DECISION DELEGATED TO HEAD OF PLANNING

Application No:	H16-0410-23	Applicant:	Mrs F T Mir Javadi
Proposal:	Change of use of residential dwelling to HMO - re-submission of H16-1111-22		
Location:	106 Halmer Gate Spalding		
Terminal Date:	23rd June 2023

HMO AT 106 VALMER GATE
SPALDING FOR
MRS F T MR JAVADI

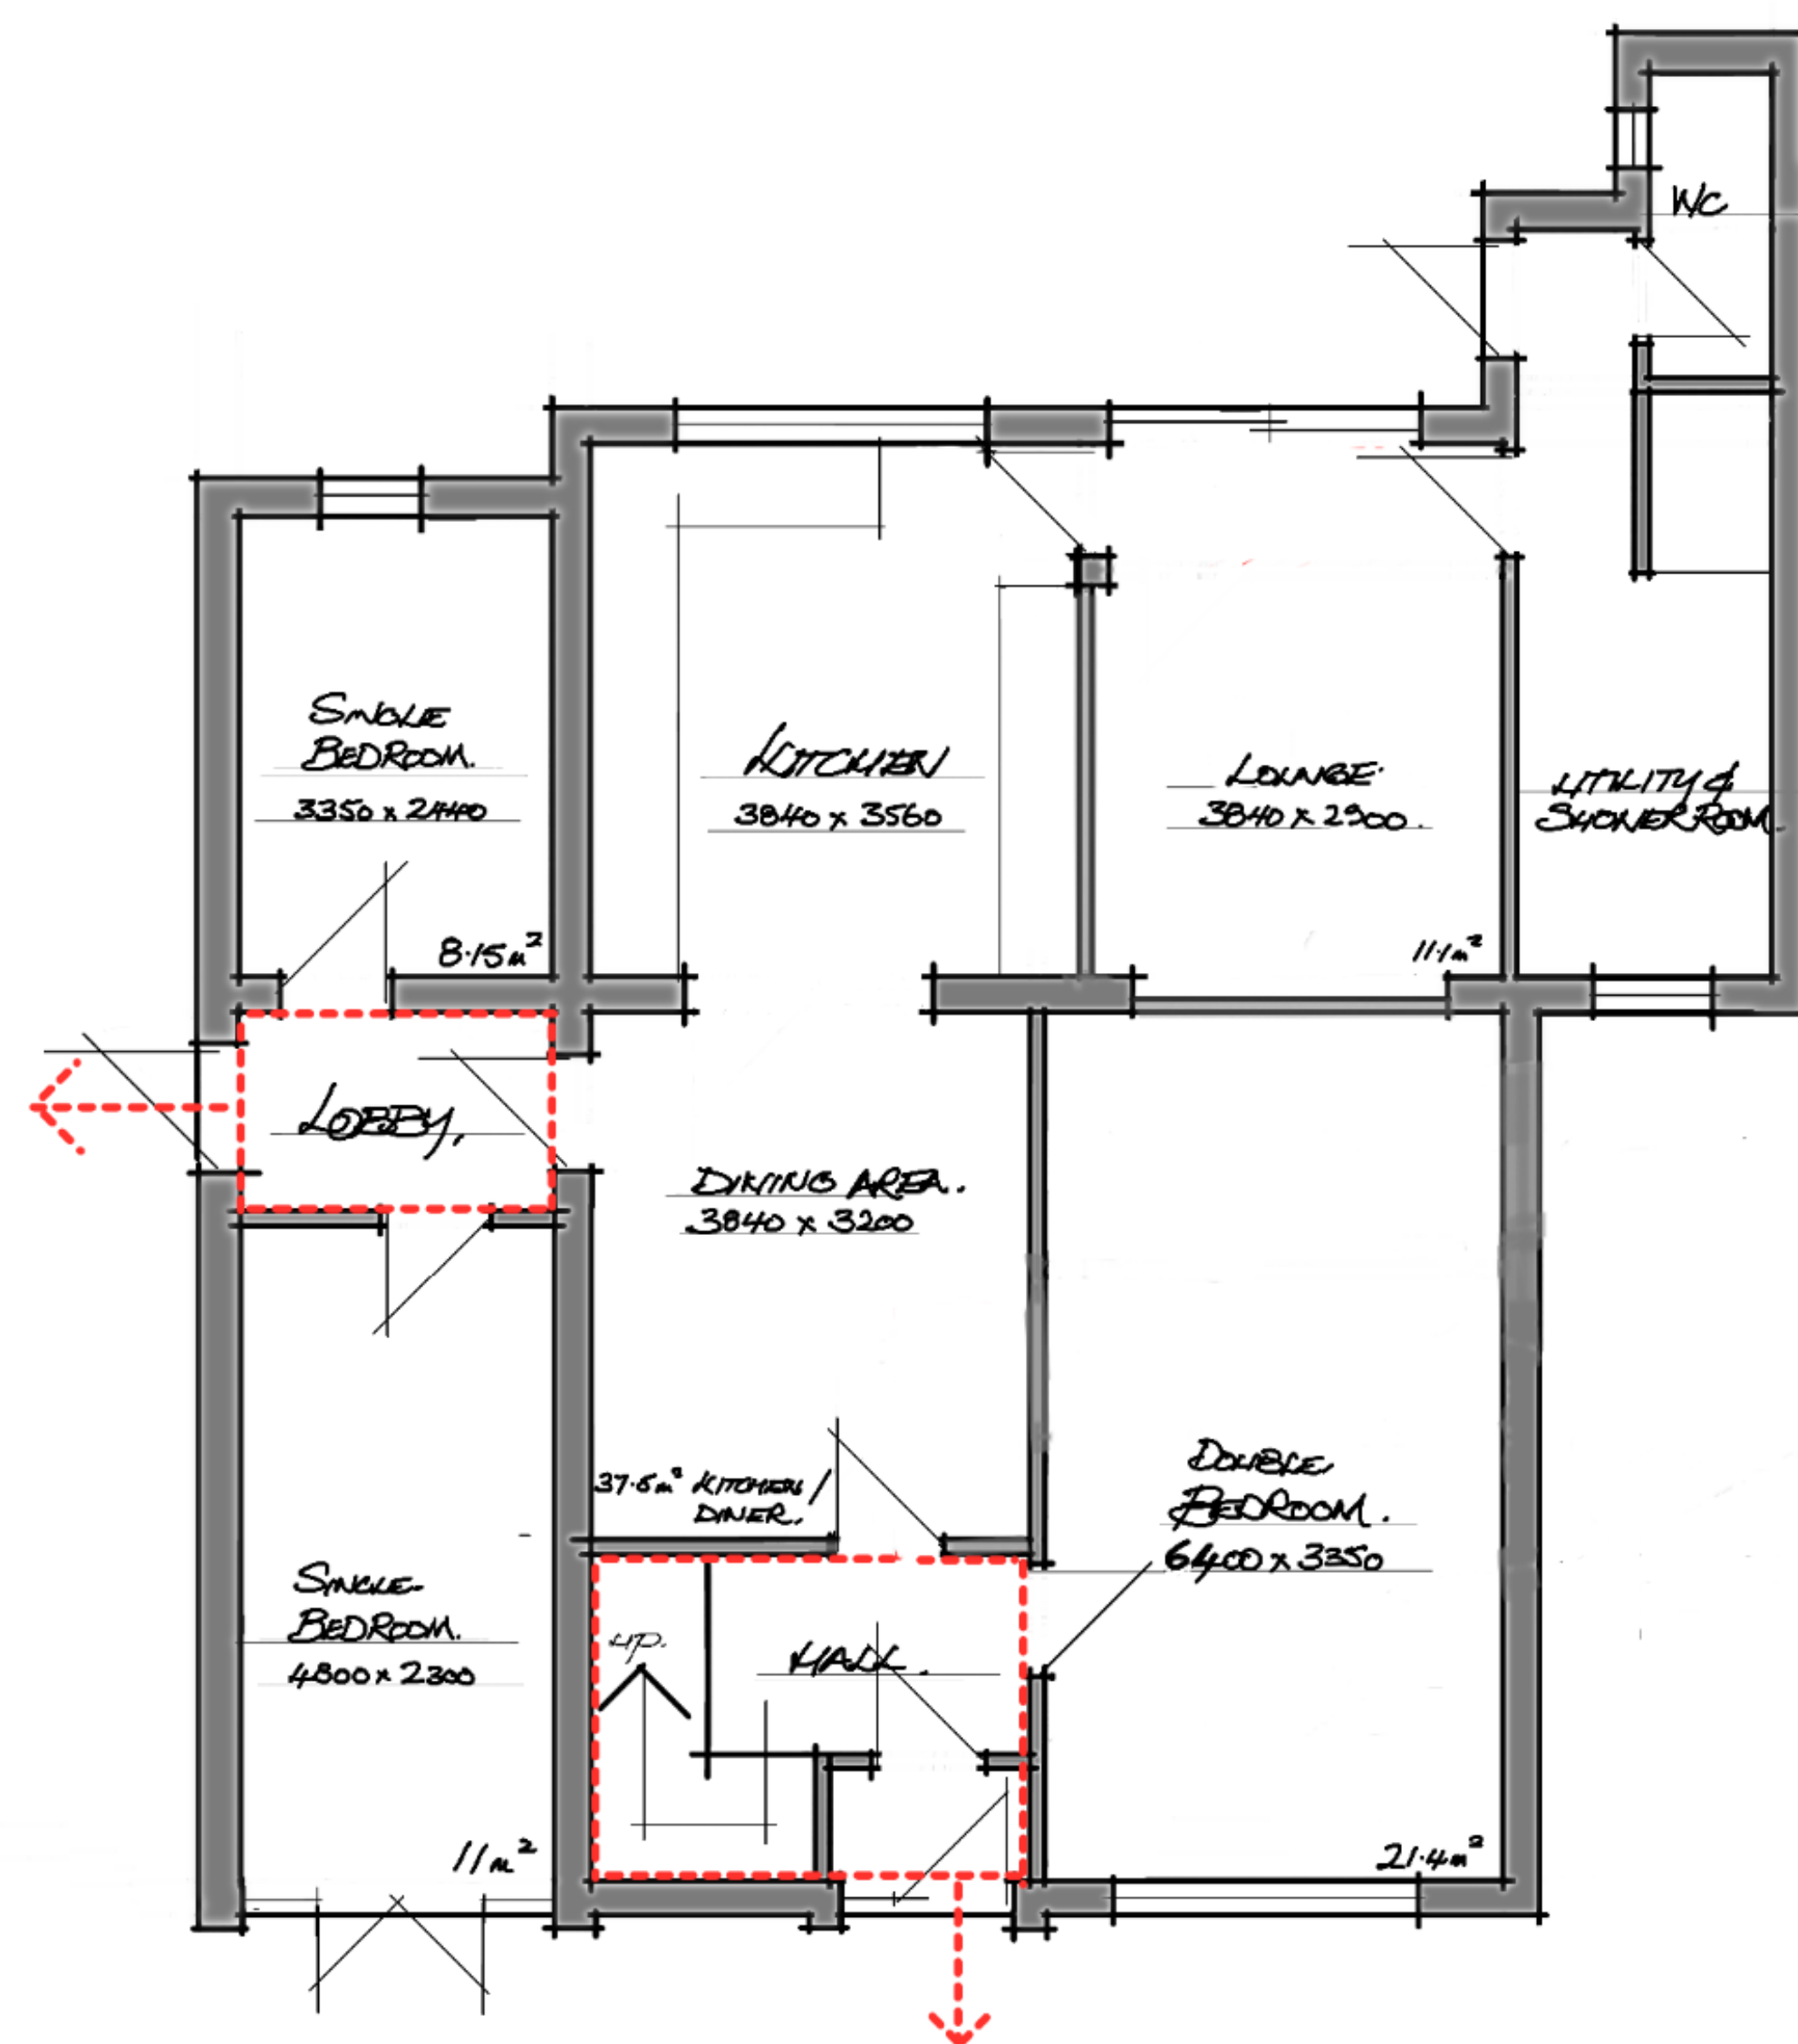
3. The proposal would not materially alter the historic or natural environment or general character of the area.
4. Provisions have been made to accommodate refuse in two large receptacles to the east of the dwelling, one for recycling and one for general refuse. This is an improvement on the previous scheme. As the receptacles will have lids, the potential for pests and noise is low.
5. There are no defined parking standards for HMOs in the Local Plan. It is proposed that five parking spaces would be provided, and that future occupants would be vetted to ensure no more than five vehicles are present. Five parking spaces is woefully insufficient for a property that would have seven or more occupants and no provisions for on street parking. A lack of off-street parking may damage the safety of highway users or the access of other residents.

The property is located close to the mini roundabout at the conjunction of four roads. Therefore, occupiers may have difficulty with pulling onto the road due to its business and a lack of visibility. This concern is compounded by a lack of turning space on the property, meaning it is possible that residents would have to reverse out onto Halmer Gate. Naturally, this is dangerous and unacceptable.

7.There is a small communal living room and kitchen proposed. While the addition of a living room is an improvement over the previous scheme, one living room and kitchen is insufficient for seven plus people and would lead to residents primarily using either outdoors or their rooms as amenity space. If the outdoor space is favoured, the potential for noise pollution would increase further. If the bedrooms are favoured as amenity space, there may be a detrimental impact on the mental health of residents.

Similarly, there are only two communal bathrooms and one ensuite. It can be assumed the ensuite bathroom would only be used by the occupant of the relevant bedroom. Therefore, there would be two bathrooms between at least six people. Again, this is not an ideal situation.

While there has been a new double bedroom created, the majority of proposed room sizes are extremely small. This will not be conducive to well-being.

The property is within Flood Zone 3. It is within the "Danger for All" hazard category within the local Strategic Flood Risk Assessment, with flood depth expected to reach 2 metres. The proposal would add bedrooms to the ground floor, bedrooms that would be severely at risk of flooding. As HMOs are often occupied by the most vulnerable members of society, the impact of flooding would be felt particularly severely on this site.

As discussed above, the proposed parking arrangements are unacceptable. Five spaces are provided, however, the spaces marked four and five would be extremely difficult to park in. It is expected that there would be up to nine residents, each potentially needing a vehicle, potentially leading to a deficit of four spaces.

No turning space would be provided, potentially resulting in occupiers reversing onto a busy road, on a bend.
